From: Amber Willard
Sent: 13 April 2026 14:39
To: Planning.Responses
Subject: FW: be/146/25/doc
Attachments: SHE-0075-2100-0550-2100_Design_Drawing.pdf; Flow Control Device.jpg; the cottage.docx

Please upload below email and attached docs for BE/146/25/DOC

Comment 2: Flow control device evidence.

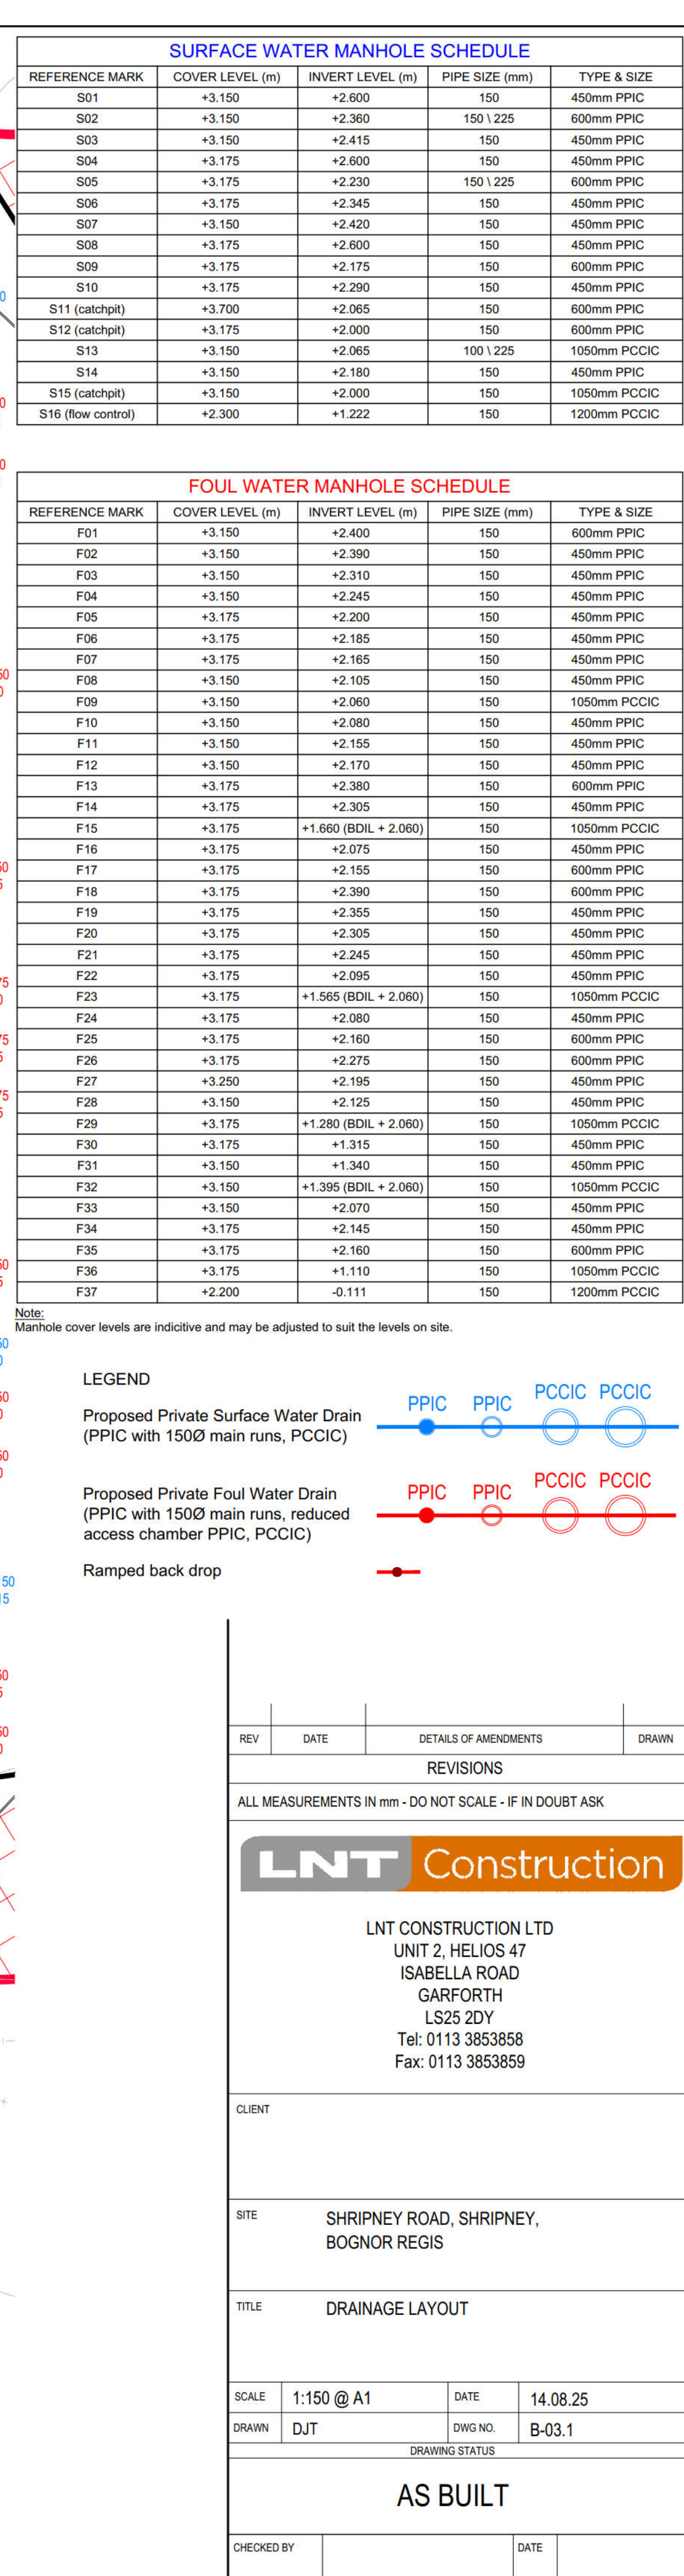
Comment 2: *"in addition to the as built plan please provide evidence in the form of photos and records particularly the flow control product including orifice size and depth to IL as the two main criteria controlling peak flow."*

Orifice size: 75mm (attached technical specification previously submitted Ref. SHE-**0075**-2100-0550-2100_Design_Drawing) The document title shows the specific orifice size of that particular flow control device (added in bold for clarity).

Depth to IL: Please see attached plan which shows the depth to IL (275mm), cut out image below for reference:
